Our ref: SSD 8970

**Physical Education Precinct for St Joseph's College (SSD 8970)
Mark Street, Hunters Hill – Response to Submissions**

23/11/2018

Street Section A

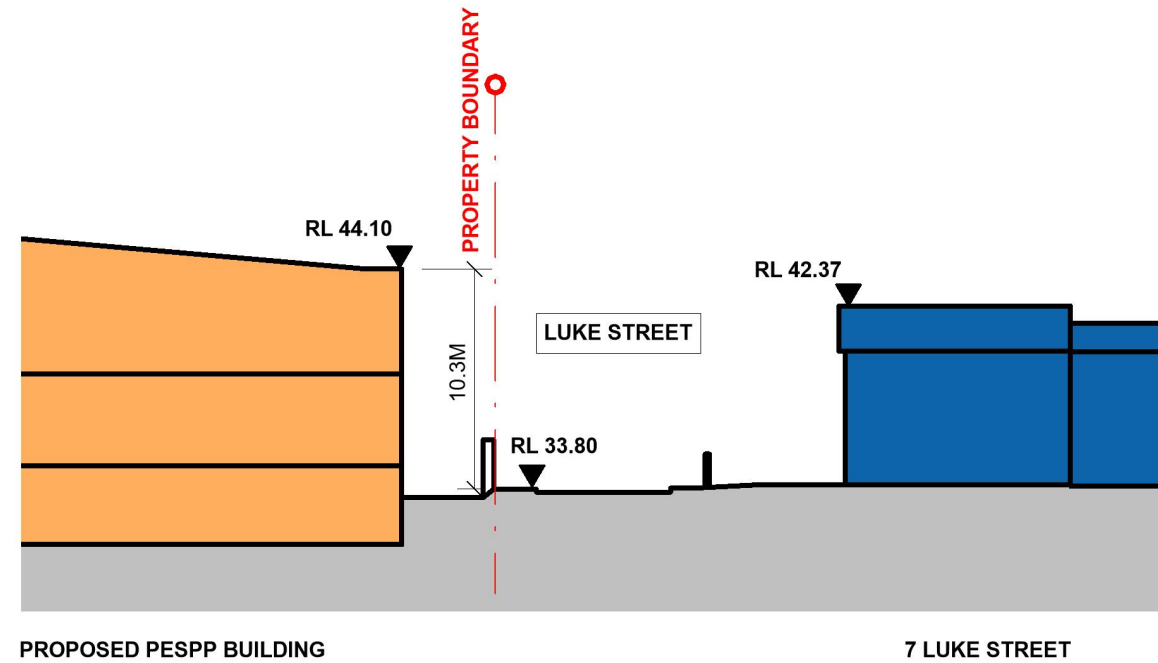
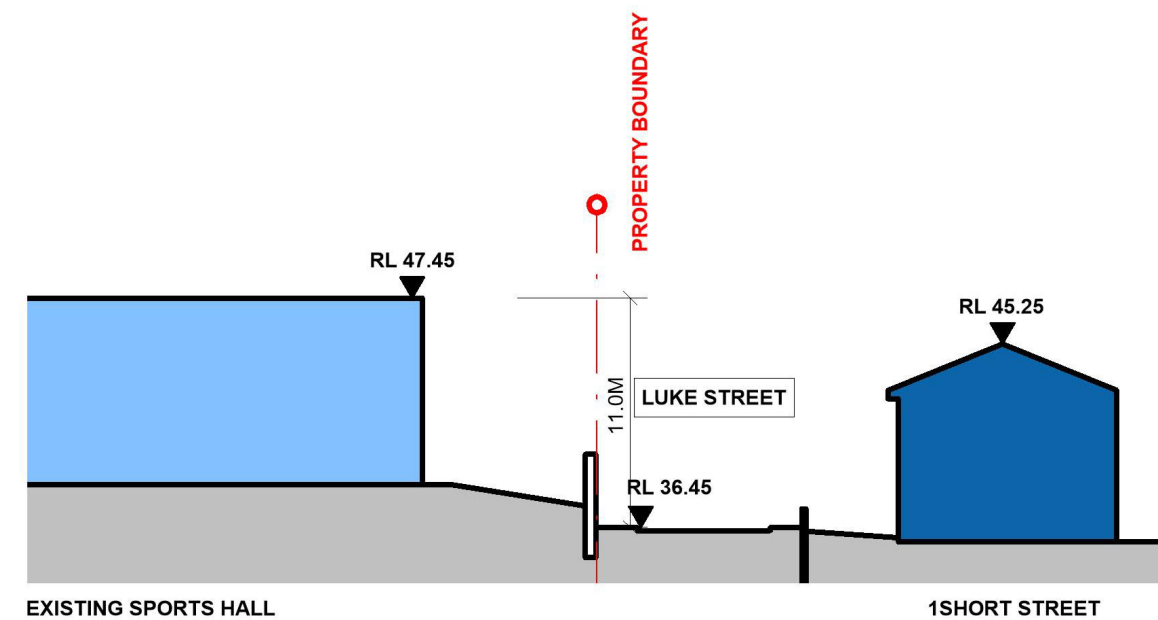
- Additional photomontages, comparing the scale of the PSEP building with the existing buildings within the site and also in the locality (streetscape sections and overall site sections), must be provided to enable detailed assessment of the visual impacts of the bulk and scale of the proposed building.

VIEW FROM CORNER OF GLADESVILLE RD AND LUKE ST

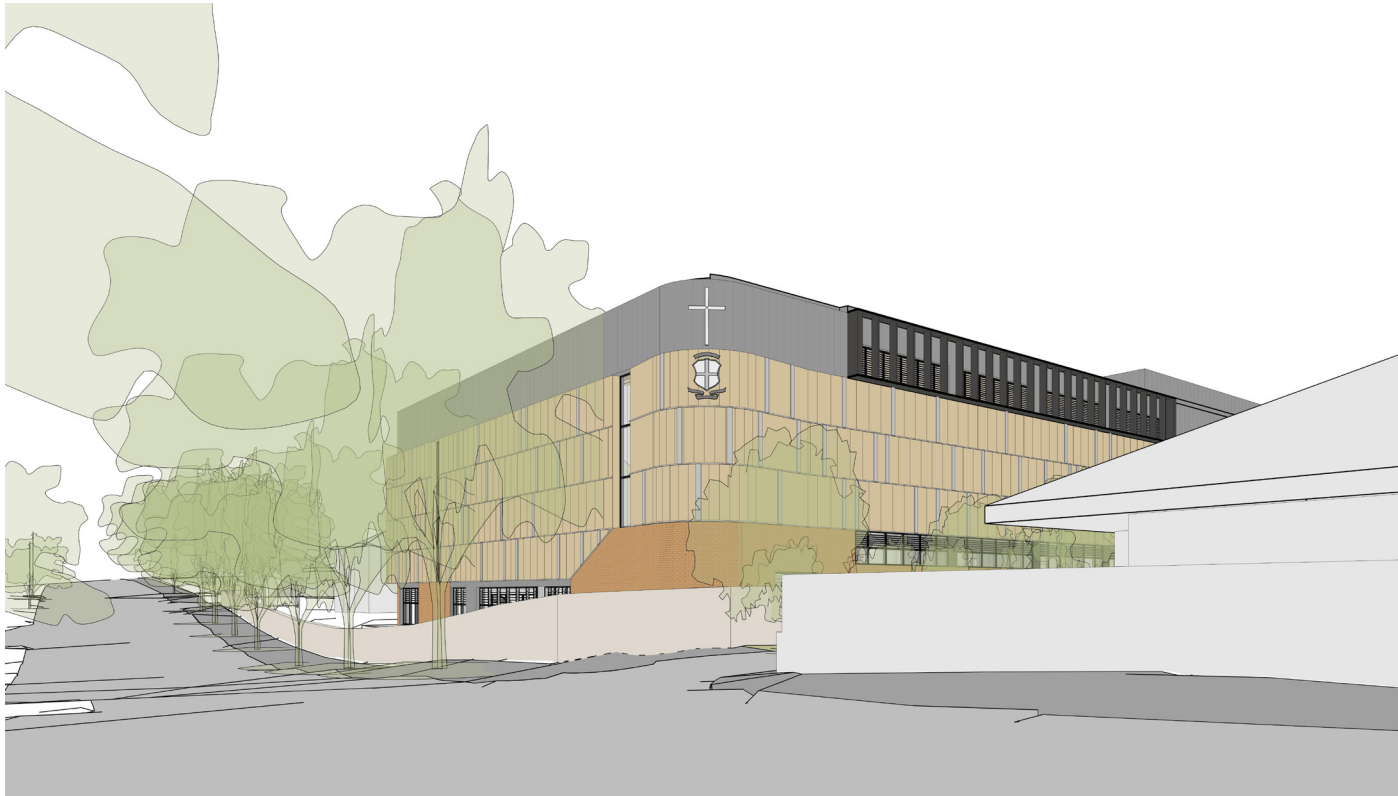
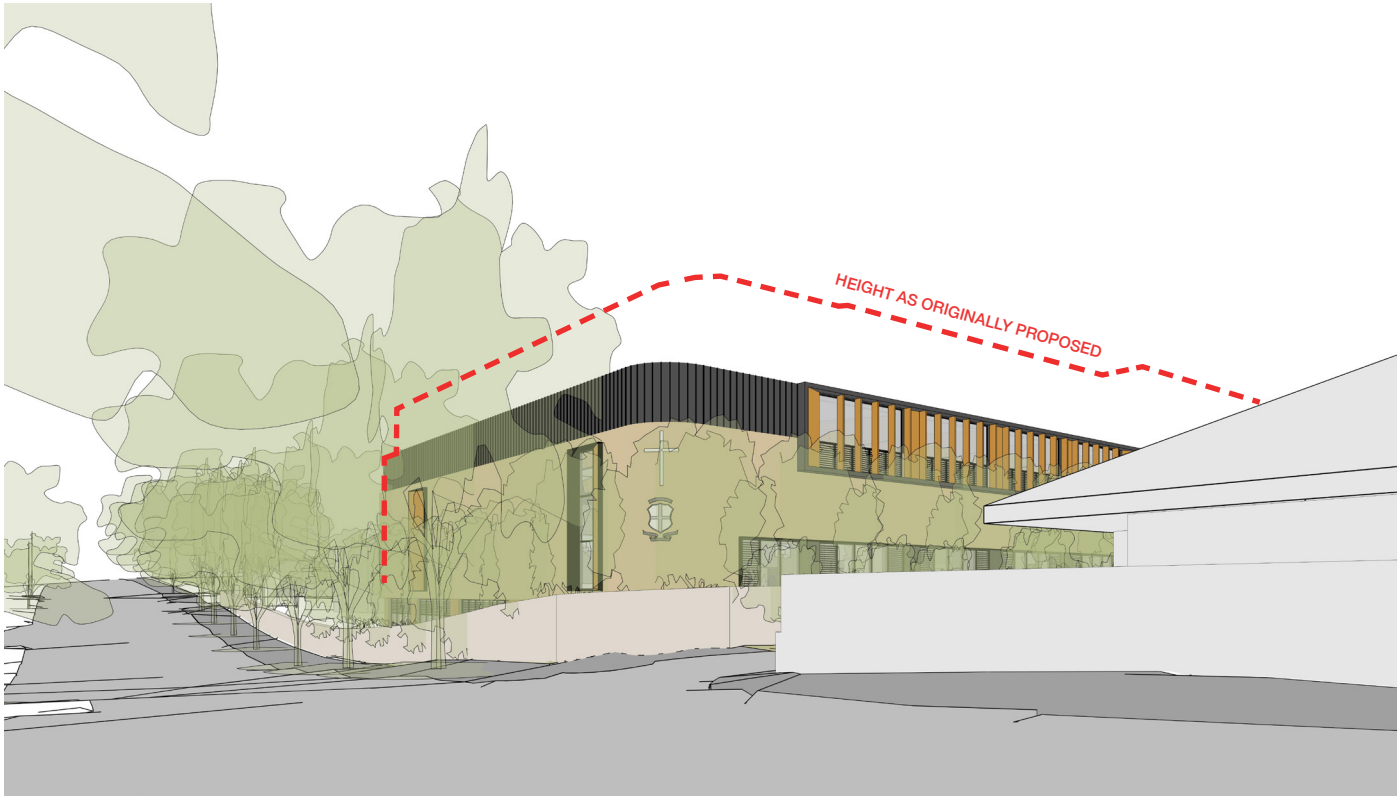
- The Department considers that the proposed bulk and scale of the Physical Education and Sports Precinct (PESP) building is excessive and would not be compatible with the character of the immediately locality or the heritage values of the Hunters Hill Conservation Area No 1—The Peninsula. The bulk and scale of the PSEP building would dominate both street frontages due to its height and lack of setbacks to the boundary.

- The Department considers that opportunities to reduce the mass of the PSEP building and increasing the setbacks of the building from the site boundaries, must be explored. These may include additional excavation (to reduce the overall height), deleting components of the building on the upper level such as meeting rooms and / or reducing the overall building footprint.
